TOWN AND COUNTRY PLANNING ACT 1990

FULL

Reference: H09-0937-23 **Date of Decision:** 21st December 2023
Applicant: Mr A Clues
Landmere Cottage
Main Road
Holbeach Drove
Spalding
PE12 0PS
Location: Rear Of Landmere Cottage Main Road Holbeach Drove Spalding
Description: Erection of single dwelling and detached garage

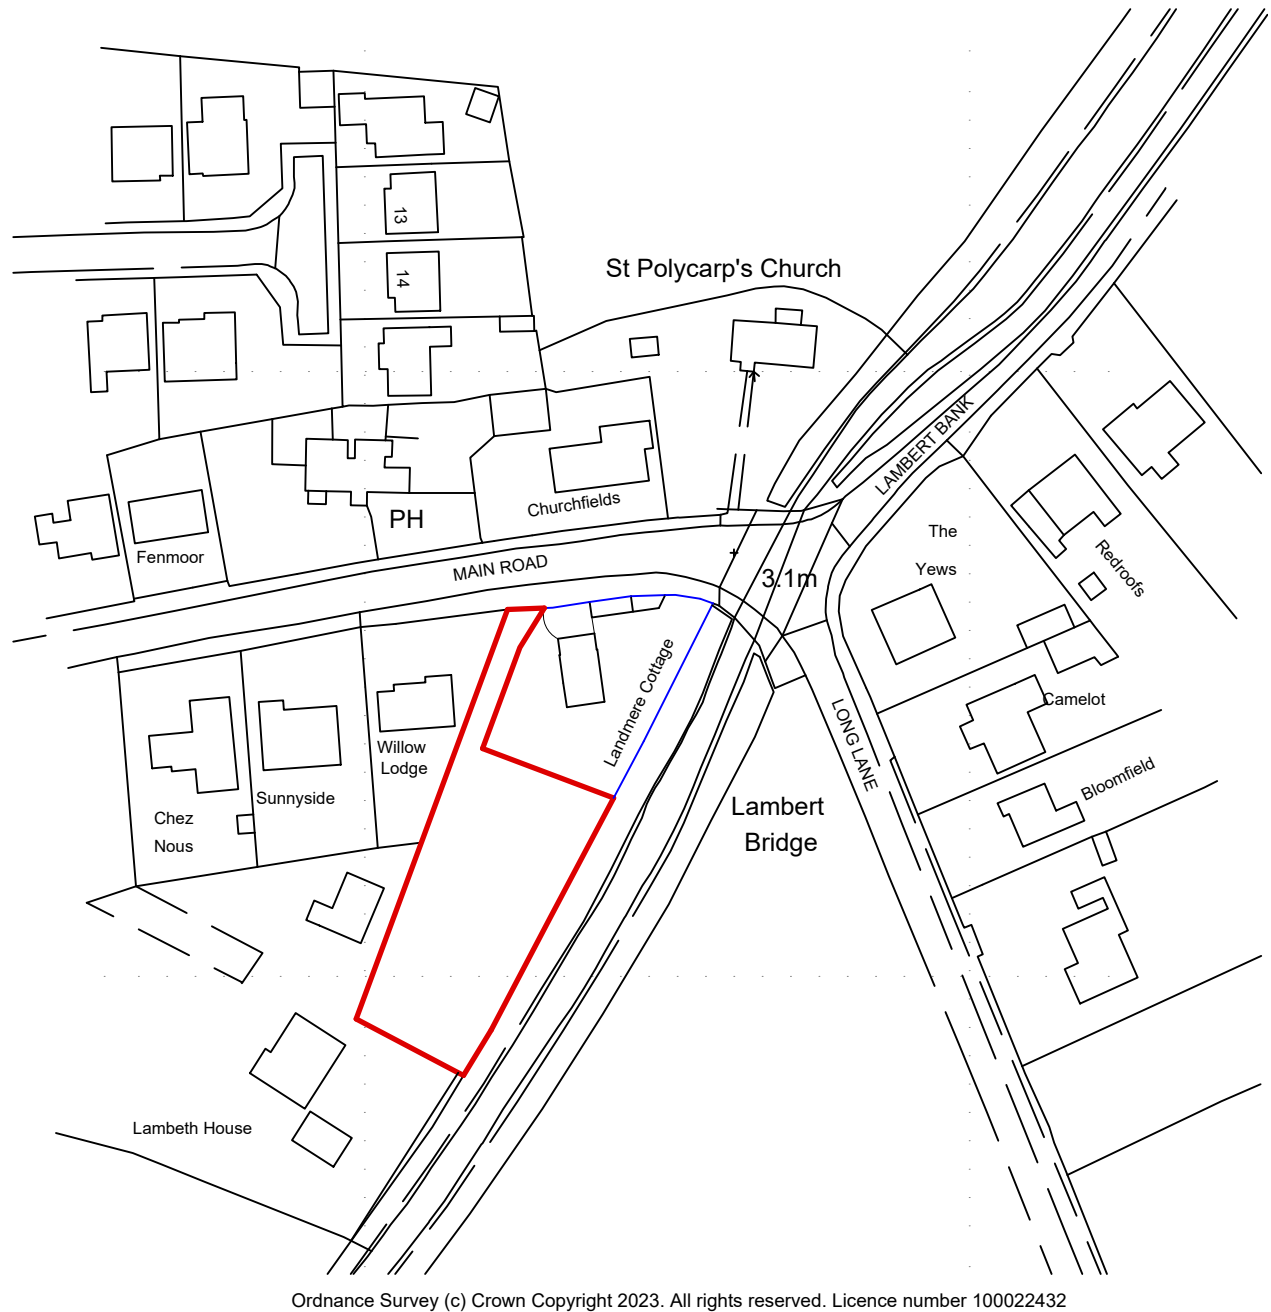
- 2 The proposal is contrary to Policies 2 and 3 of the South East Lincolnshire Local Plan, 2019 which amongst other things require proposals to have regard to the character and appearance of an area. They stipulate that proposals which fail to maximise opportunities to improve the character and quality of an area will not be acceptable. The design and size of the plot are significantly different when compared to immediate neighbouring

properties in the area, as such, this makes the proposed single dwelling appear incongruous and out of character.

- 3 The proposal by virtue of its scale and siting alongside the small boundary treatments would result in both an overbearing and overshadowing impact upon the existing residents of the bungalows to the south west of the site. Alongside this, the positioning and placement of first floor windows would provide a direct view into these plots rear gardens and therefore result in a loss of privacy. The proposal is considered to be contrary to Policies 2 and 30 of the South East Lincolnshire Local Plan 2019 as well as Paragraph 135 of the National Planning Policy Framework December 2023.
